RE: The Springs Of Ballentine

*40 Rawls Club Road
Fuquay-Varina, NC
Mr. Taylor,*

The following is a response letter for the above referenced projects review comments of May 09, 2023.

Scale:  
1/8" = 1'-0"

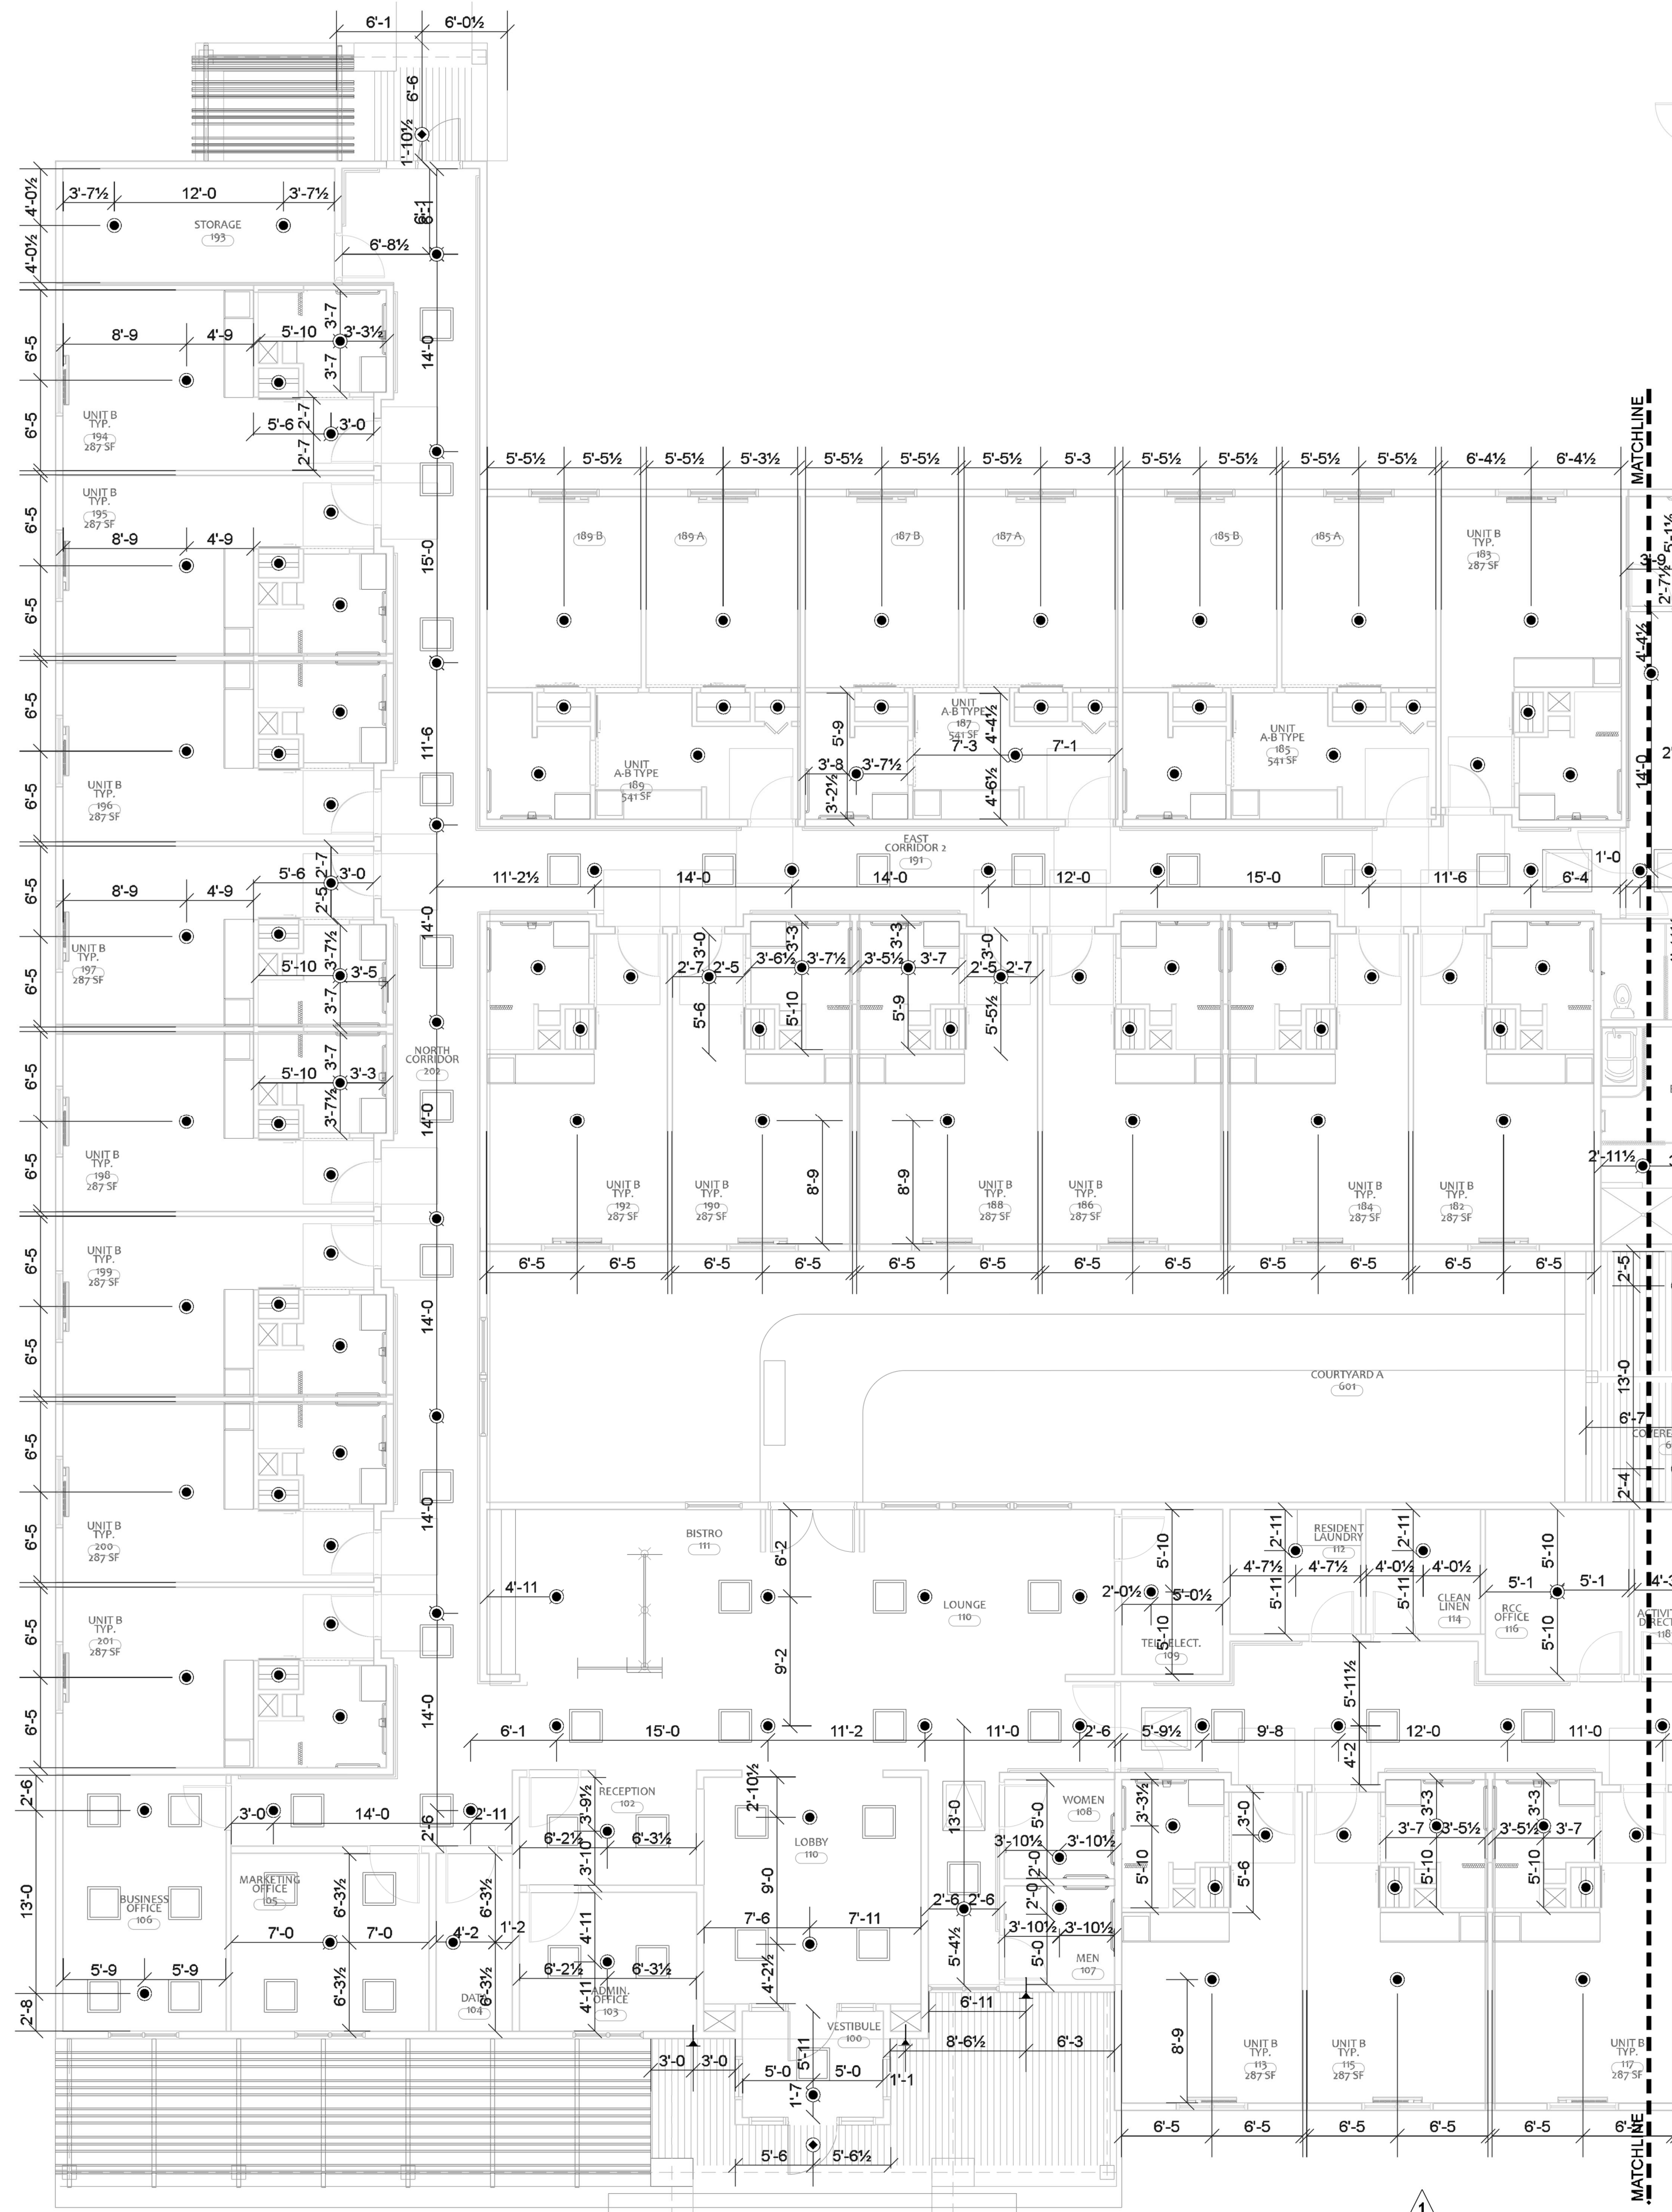
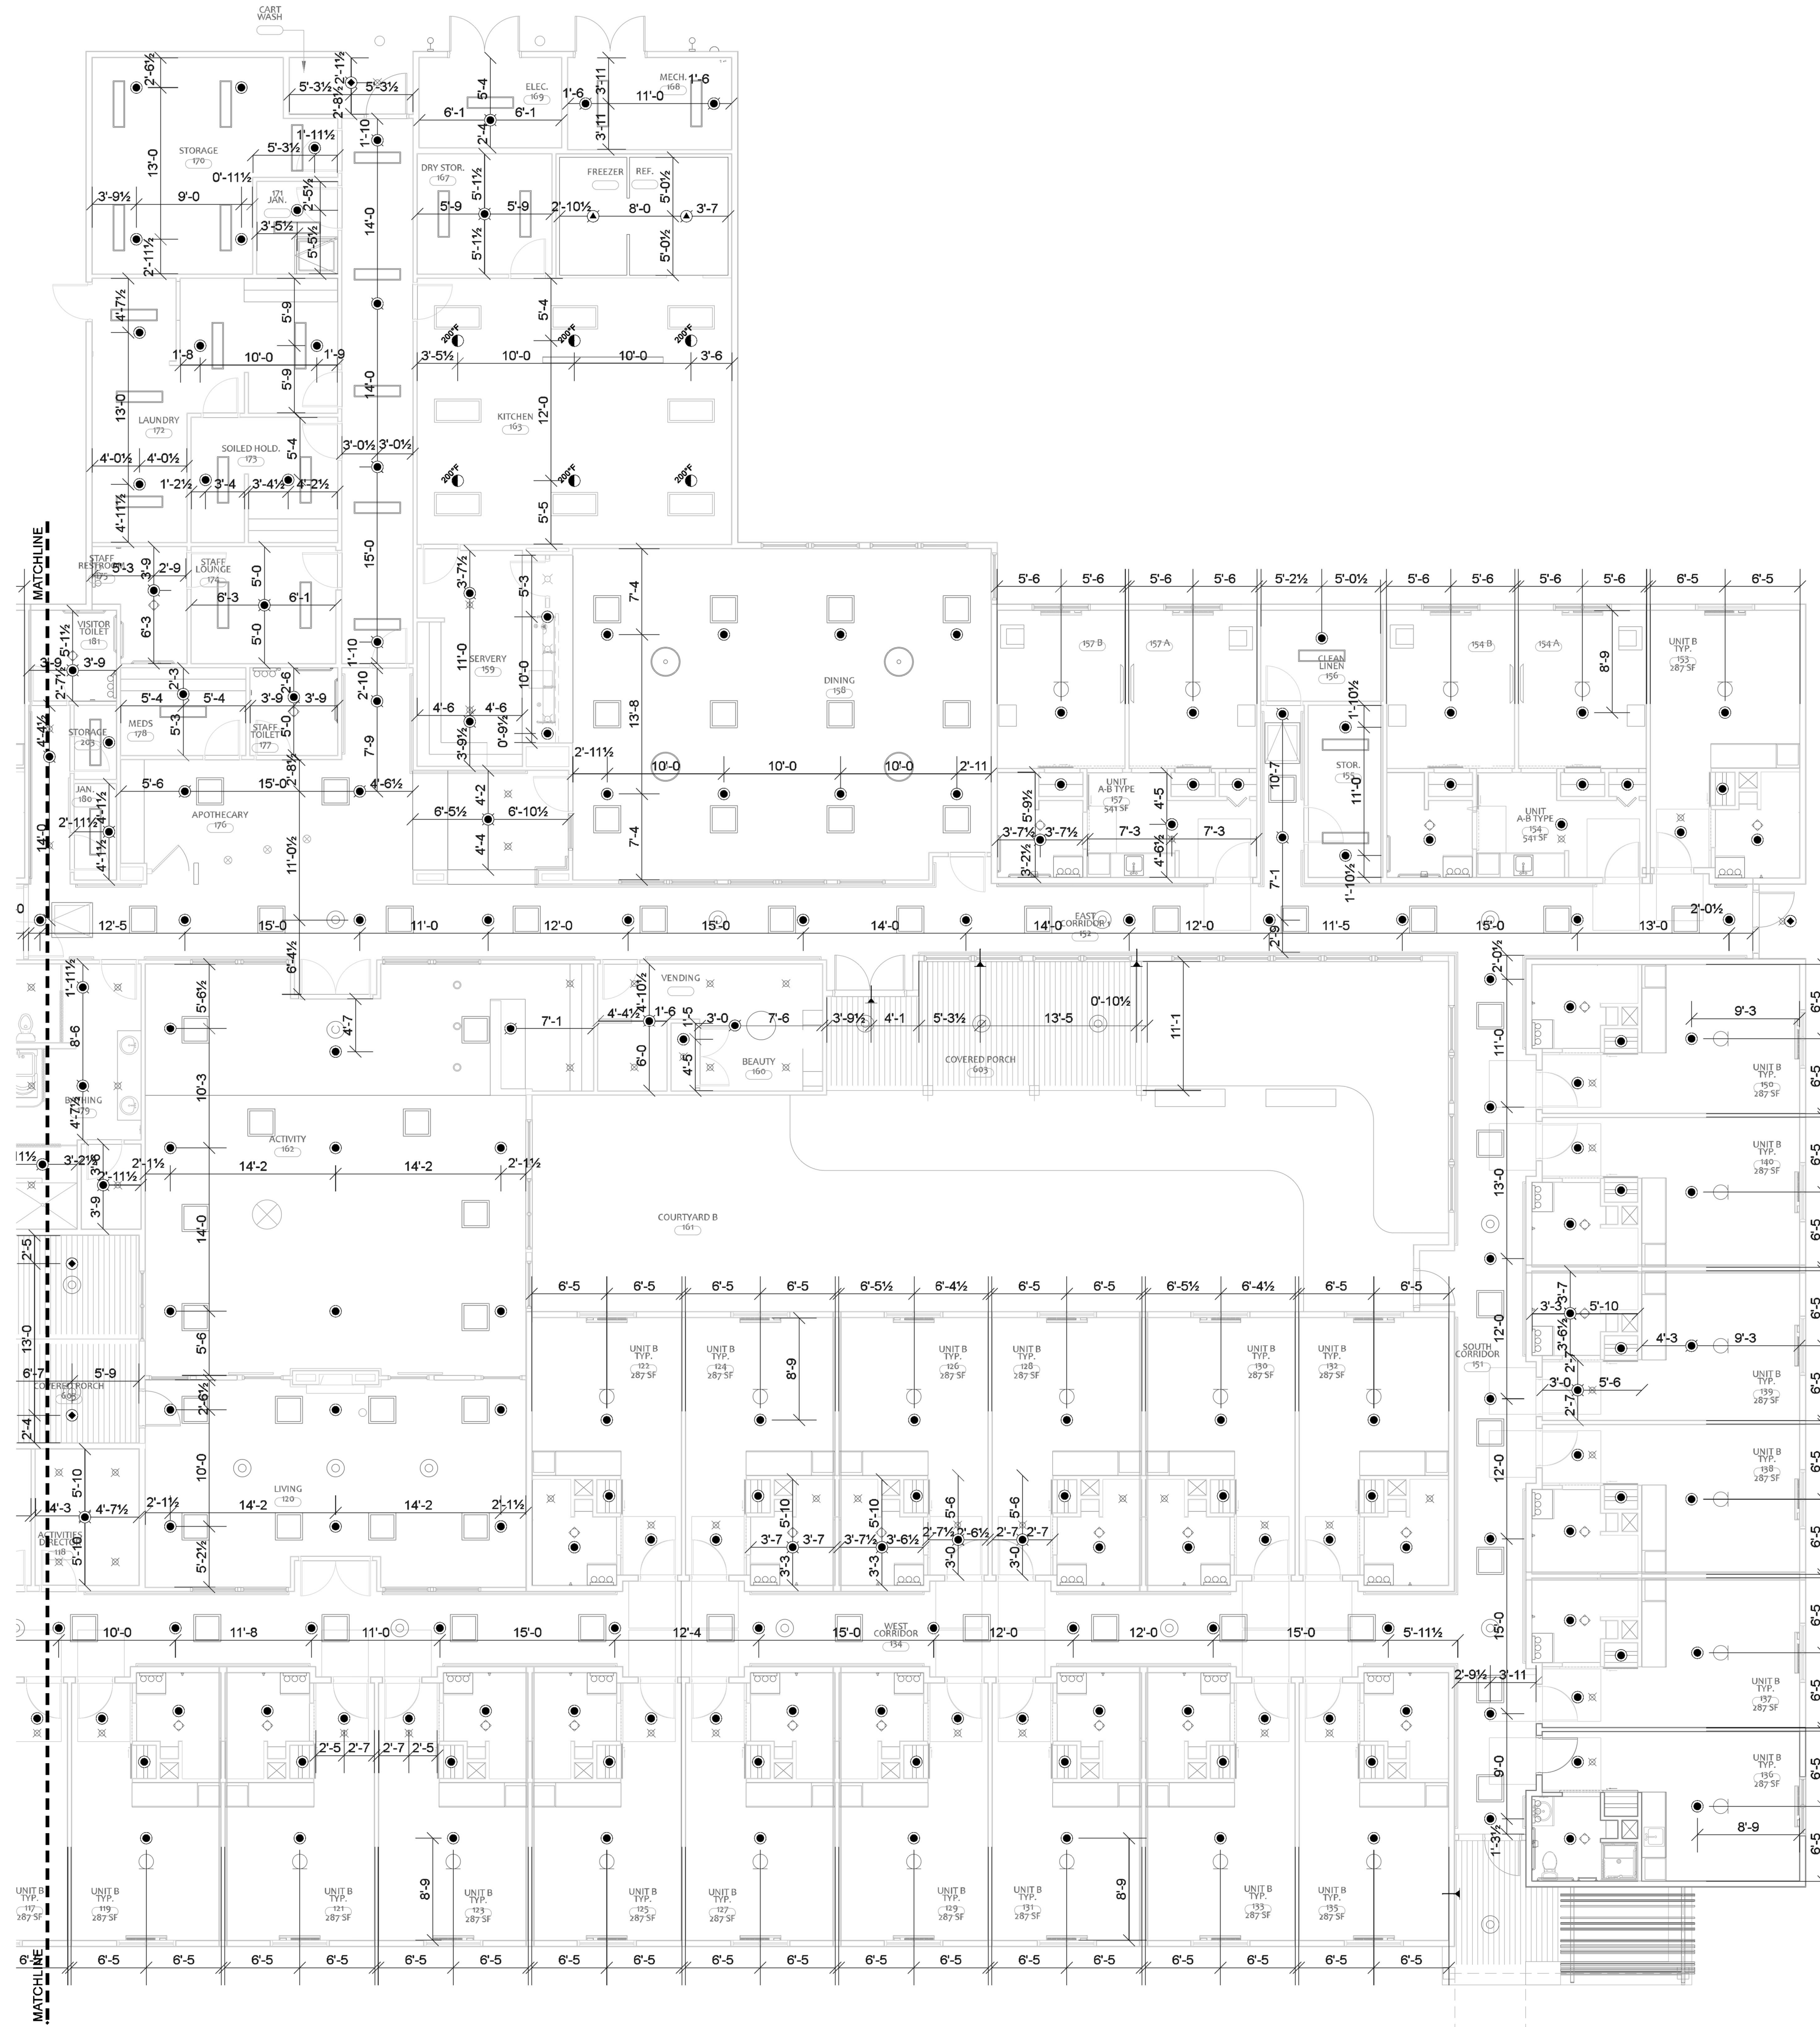
Comment 2: Provide full height cross section, or schematic diagram, including structural member information per NFPA 13, Chapter, Section 23.1.3 #4.
Response 2: Full height cross section now included on page FP-2.

Comment 5: Provide total area protected by each system on each floor per NFPA 13, Chapter 23, Section 23.1.3 #14.
Response 5: Total area protected by Sprinkler System is now noted under the "Sprinkler Design Data" section on FP-1.

Comment 8. The symbol for heads provided in Activity 162 & Lobby 110 are not listed in the Sprinkler head legend.

Response 8. Sprinkler head legend has been corrected & now reflects VK3021 Semi-Recessed Pendants.
